10 March 2021

WaterNSW Ref. D2021/21308

WaterNSW submission to Environmental Impact Statement - Wongawilli Mine Modification 2 (MP 09_0161 MOD 2)

Figure 3: Cross-sections of NW Mains and NE Mains.

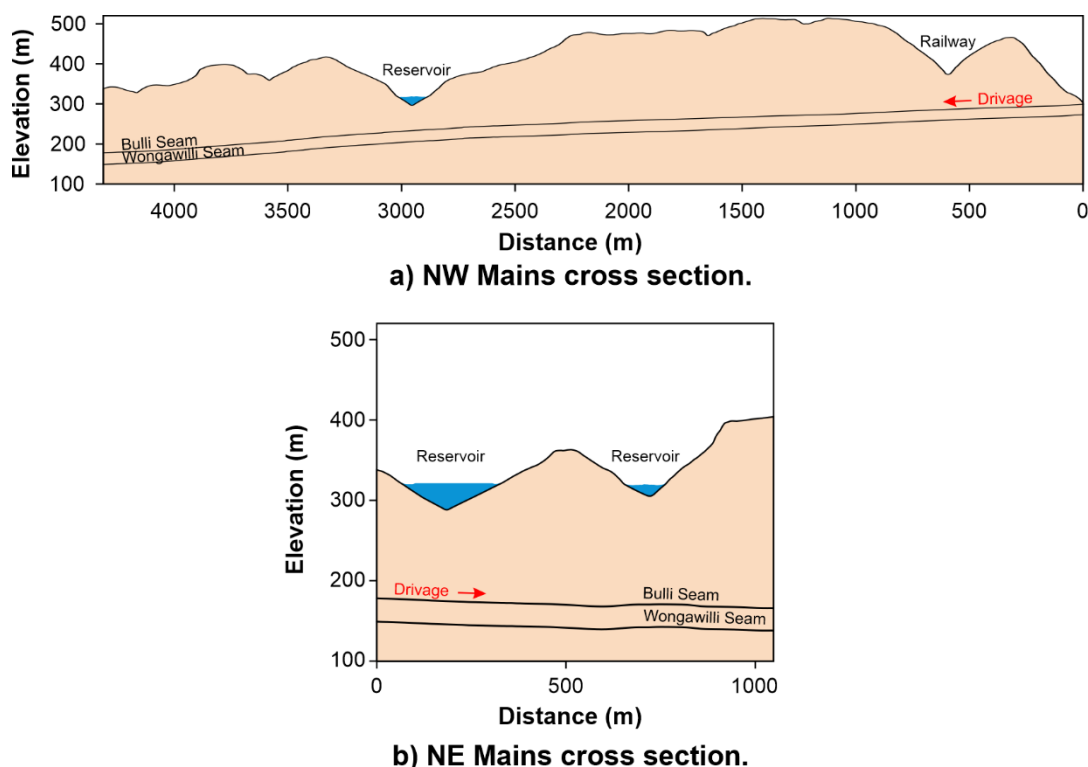
However, within the project area, WaterNSW notes that that base of Lake Avon is located below the Bulgo Sandstone in the Stanwell Park Claystone. WaterNSW seeks clarification as to how close cracking from the void will be to the base of Lake Avon.

Figure 5: Plan of Proposed MOD2 Layout relative to geological structure and existing mine workings.

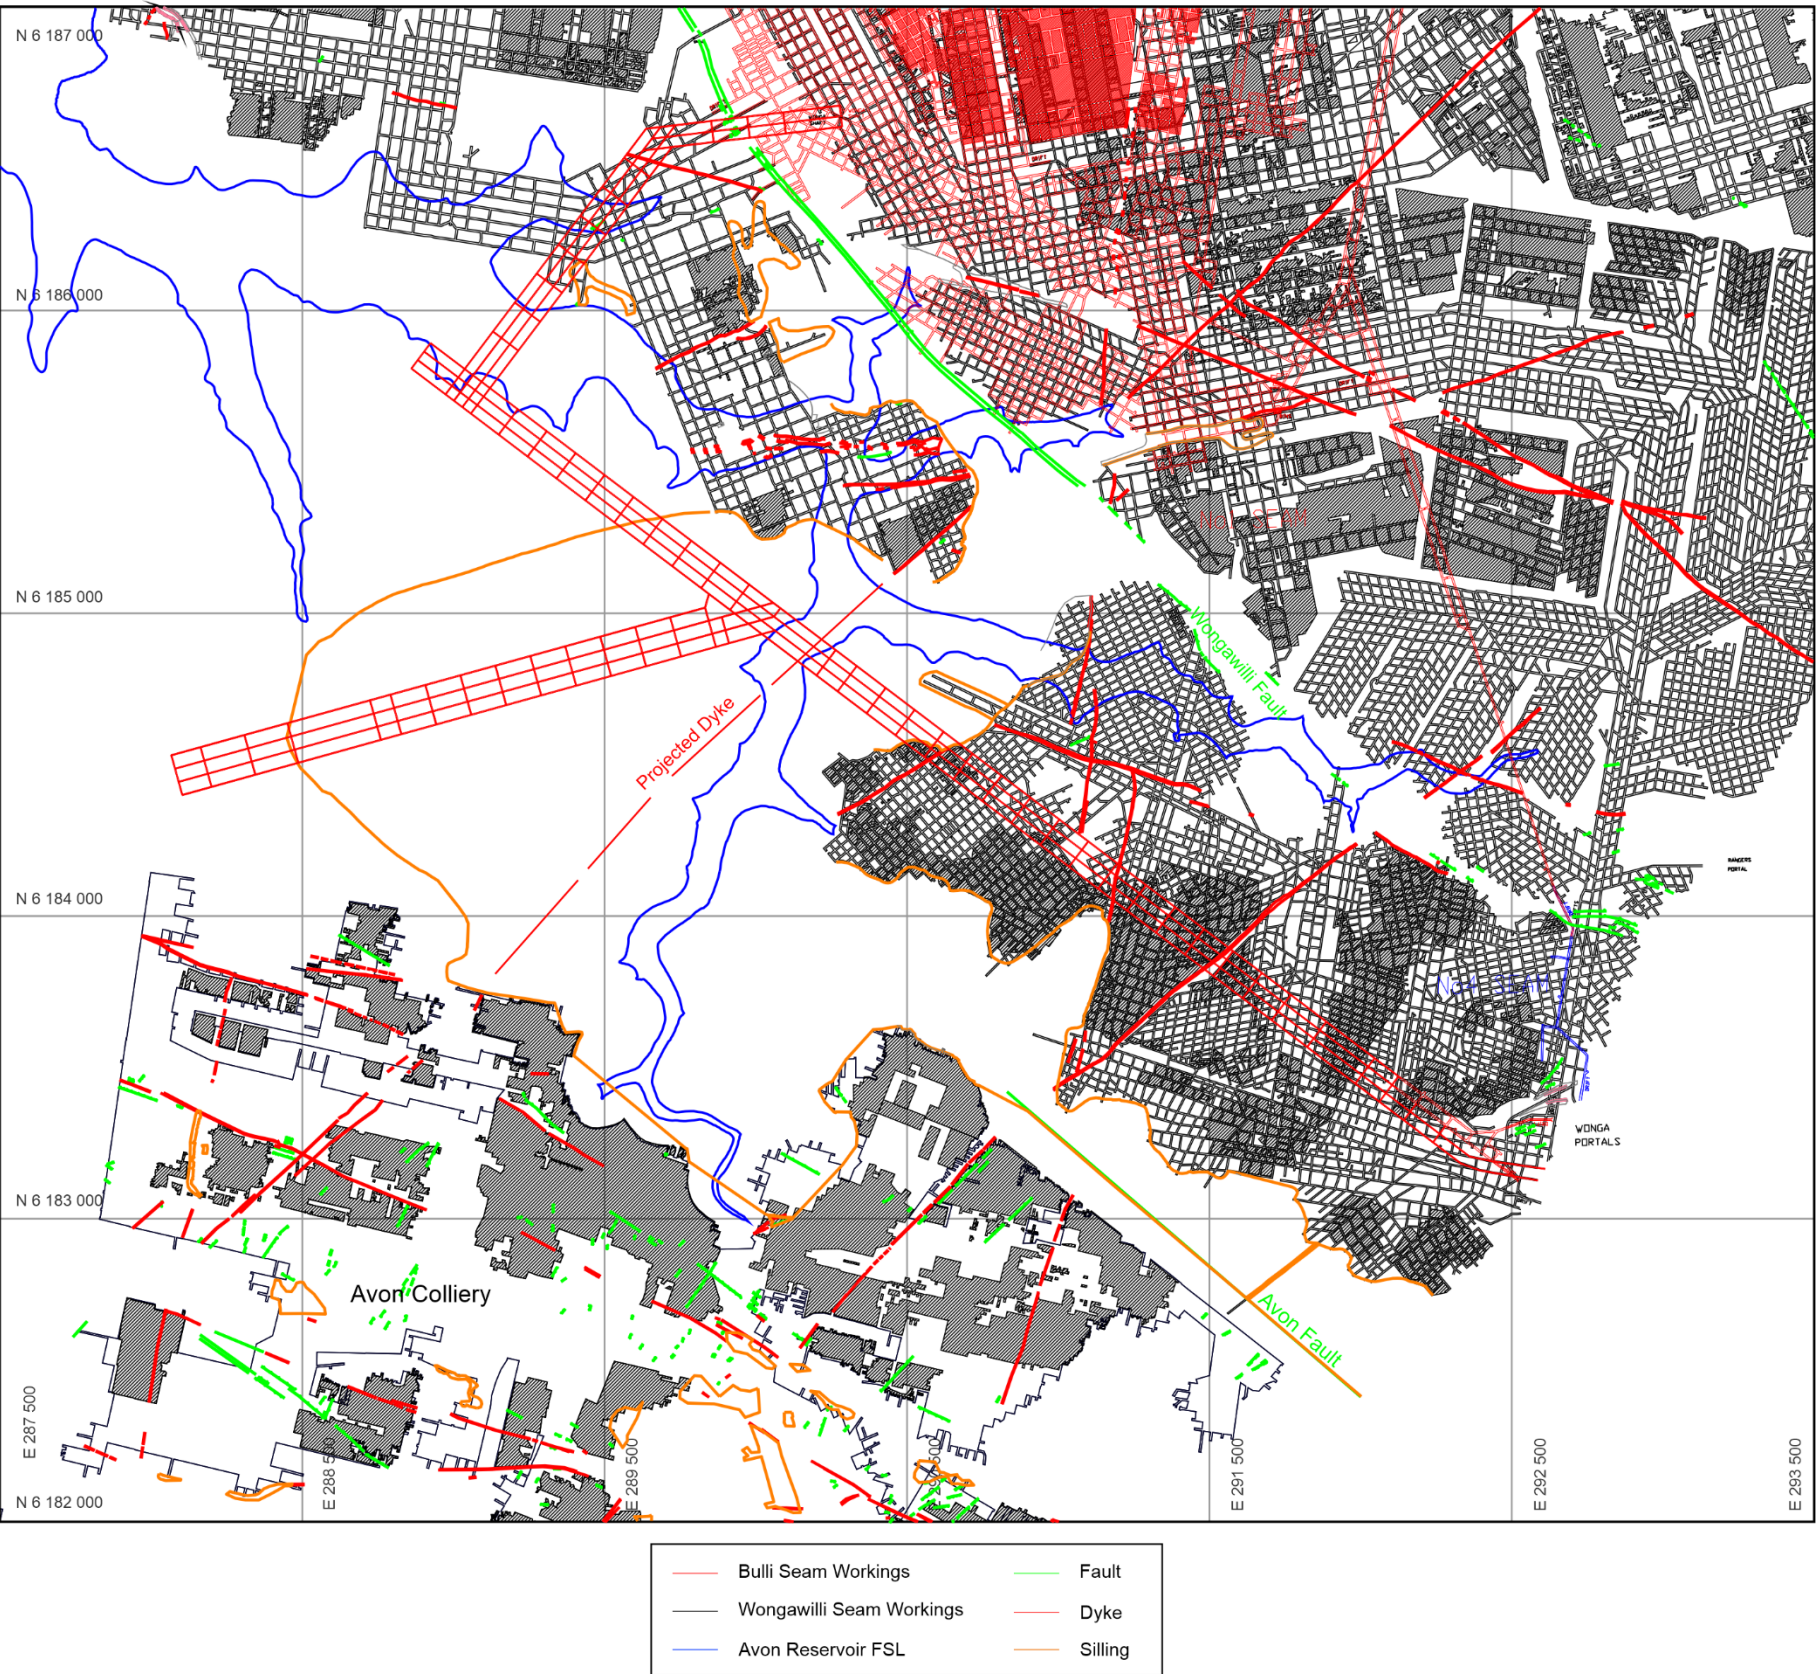
The proposed modification would extend the main drive through the Wongawilli fault and a known dyke. No subsidence predictions have been undertaken because the impact due to first workings is considered insignificant. Nevertheless, WaterNSW considers that the following matters should be further addressed:

- The potential for increased stresses above the previously extracted Wongawilli Seam.
- The impact of mining through the Wongawilli fault.
- Interactions with the dyke, noting that a steady inflow of water was observed during previous mining, consistent with an increase in hydraulic conductivity. It is acknowledged that this occurred during secondary extraction, rather than during first workings. However, given that this dyke will be intersected by the proposed modification below the surface of Avon Reservoir, it requires detailed assessment.

- a subsidence monitoring program for measuring stresses and pillar performance, and
- drilling ahead to confirm the absence of zones of elevated hydraulic conductivity and to manage any inflows from the reservoir into the first workings.
